Item No. **Report of the Interim Director of Planning, Regeneration & Public Realm**

Address 11 BIRCHWAY HAYES

Development: Conversion of dwelling into 2 self-contained flats with the erection of a ground floor front extension and part single, part double storey rear extension

LBH Ref Nos: **75827/APP/2022/1355**

PROPOSED GF & FF LAYOUT
Scale 1:100

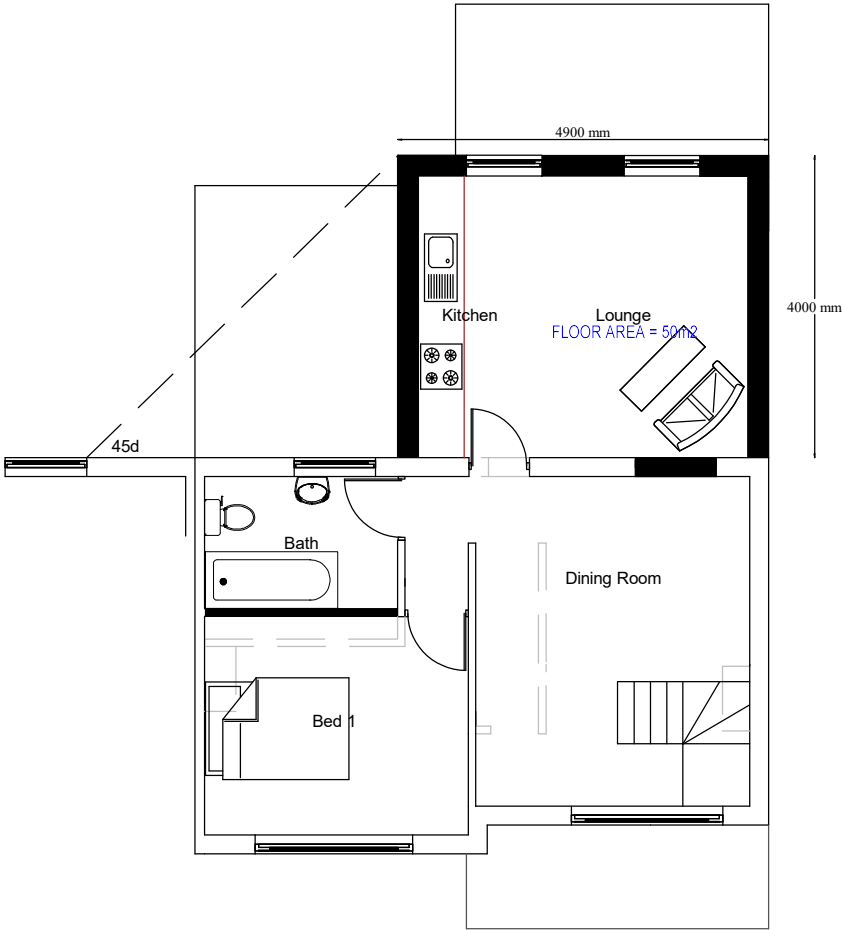
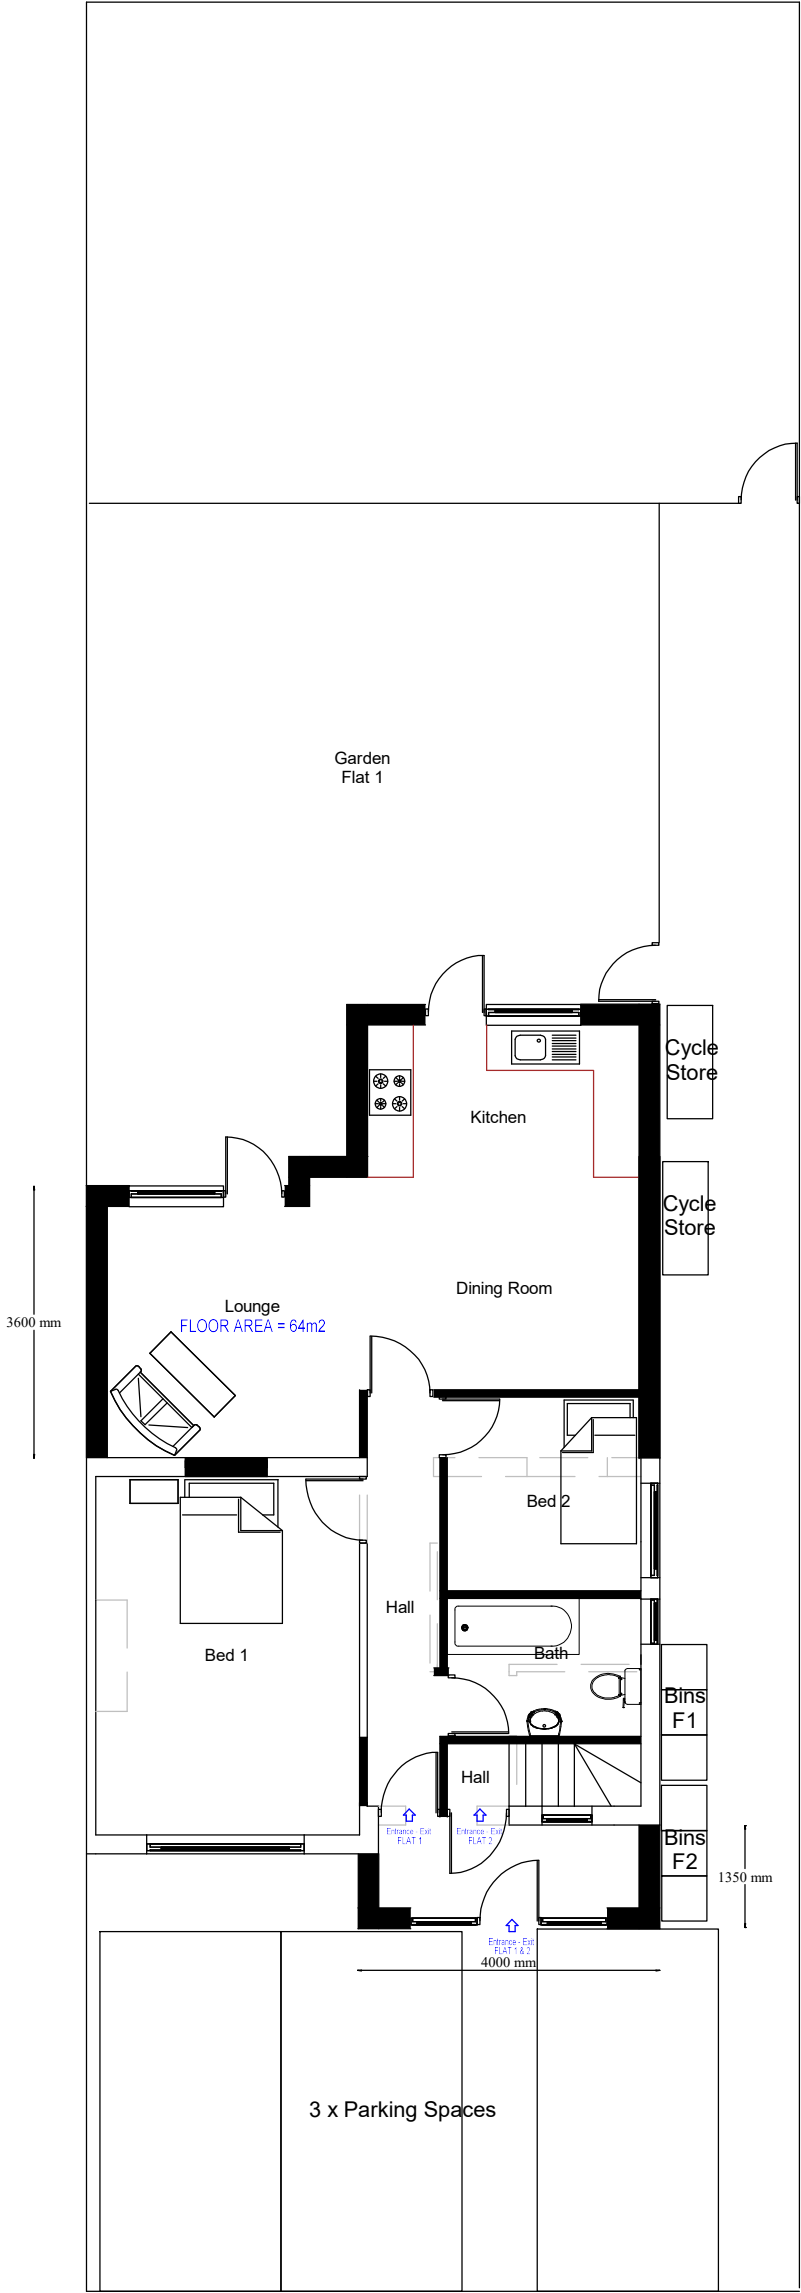
The proposed part single, part two storey rear extension would be sited to the rear of the building where it would have no impact on the character or appearance of the area. Nevertheless the single storey rear extension would be a maximum of 6m deep at ground floor and 4m deep at first floor. The extension would engulf almost the entire rear elevation of the property, obscuring its original rear wall almost entirely, with a notable footprint. Due to its height, width, depth, bulky roof and footprint the extension is considered to form an oversized and disrespectful addition to the dwelling which would harm its character and appearance.

As this represents an excess of provision as compared to the LP standard, it is recommended that the proposed quantum is reduced to 2 spaces (retaining the double bank in front of the bay window) which is more akin to the regional standard. In any event, this reduction is also considered necessary as an existing street tree would physically prevent access to the remaining third space rendering it ineffective.

Access to one of the proposed parking spaces would involve the removal of a tree which is outside of the development site. This is unacceptable.

Furthermore, the submitted plans show the creation of 3 parking spaces, this is likely to result in the creation of a full width crossover and dropped kerb at the front of the site. The crossover and parking arrangement would lead to the loss of an important tree (which as mentioned above is unacceptable). The full width cross over would also endanger pedestrians as there would be no middle point of refuge to stop while vehicles enter and exit the site. This would create a more hazardous environment for pedestrians and the sites car users.
